Your Ref: OWPC21846
Our Ref: M/24/19/PL 06-03-2019
Please ask for:
Andrew Wood

Replacement residential dwelling. This application may affect a Public Right of Way.

3 The Hard Elmer

PROPOSED FIRST FLOOR PLAN 1:50

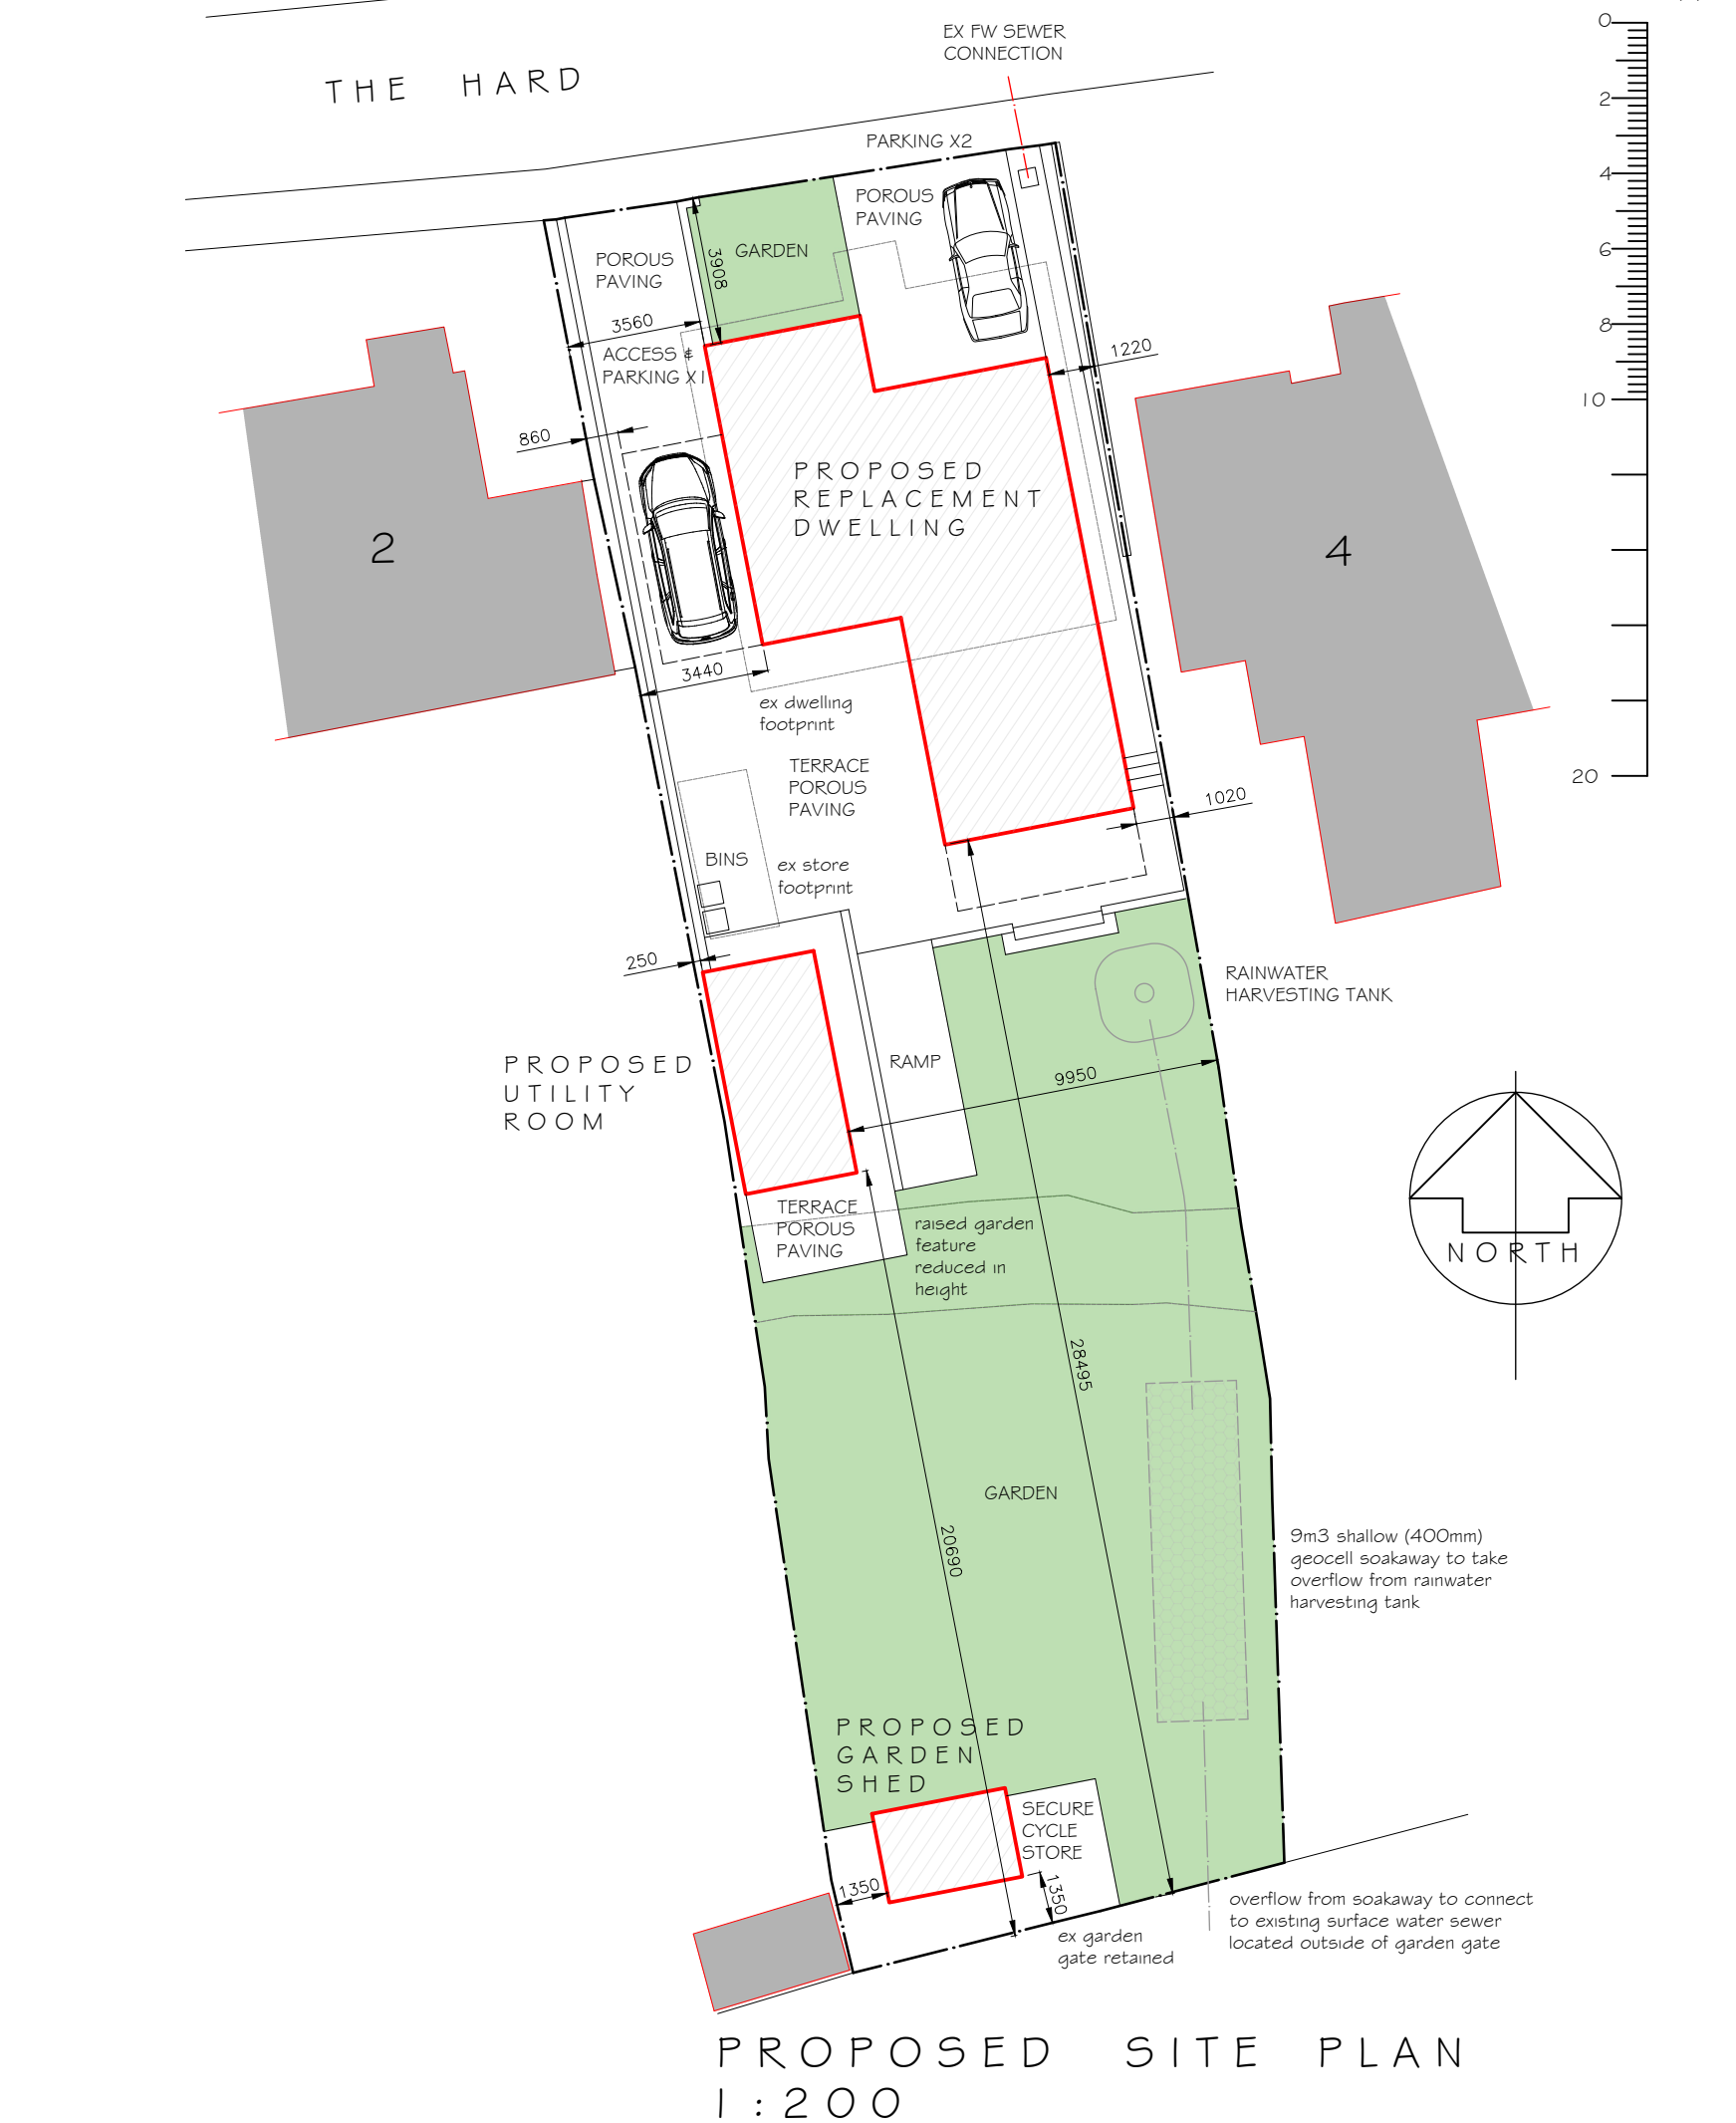
The proposed site plan 13/03/2019 shows the intention to modify or remove the floodbank - 'raised garden feature reduced in height'

Therefore the flood bank in the garden should not be flattened or modified, unless it is to increase its height.
